Response to Planning Application

From: Arun District Council Greenspace

Application ref: AB/148/21/PL

Location: 7 Canada Road Arundel BN18 9HZ

Site Plan 1:200

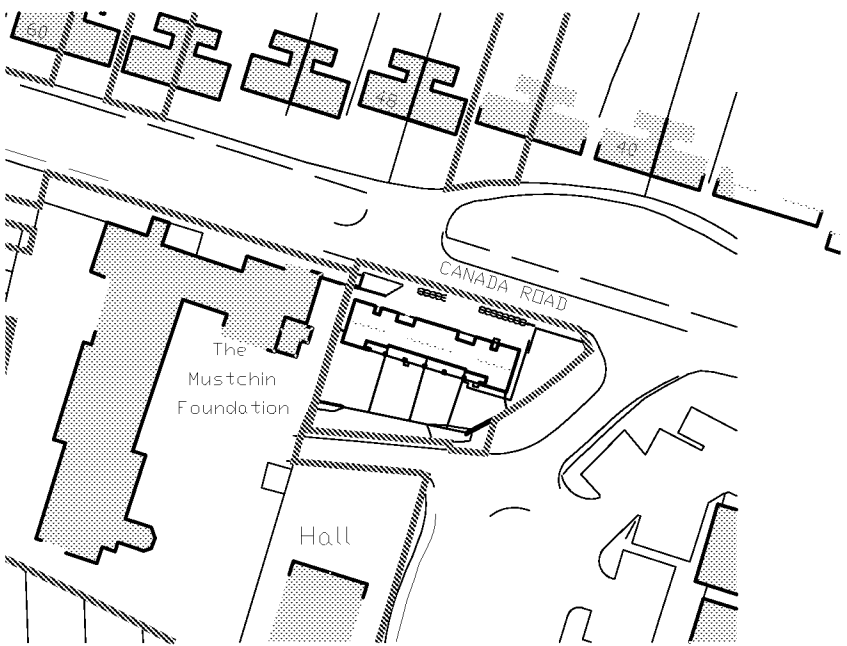
The proposals and DAS have shown indicative landscaping with planting indicated to ensure a soft visual imprint on the landscape and include buffers to be formed along the front and northern edge of the proposals.

If approved landscape details would need to be submitted in the form of a detailed planting plan and specification detailing species choice, actual plant quantities, planting densities and size at time of planting. Detail should also be provided regarding existing trees and boundary planting.

Landscaping would need to be provided, all proposed planting should consider the setting of these proposals and the neighbouring properties in this location. Trees, shrubs and ornamental planting would need to be specified at a size to allow instant impact, but which would establish and mature as the site develops. A full landscape scheme will need to be submitted for approval, or conditioned as part of any approval; detailing species choice, position, densities and size at time of planting. This should be plotted in plan and list form and in relation to the trees and vegetation to be retained so that a clear picture of the proposals can be seen. These details are required to ensure that appropriate mitigation is incorporated.
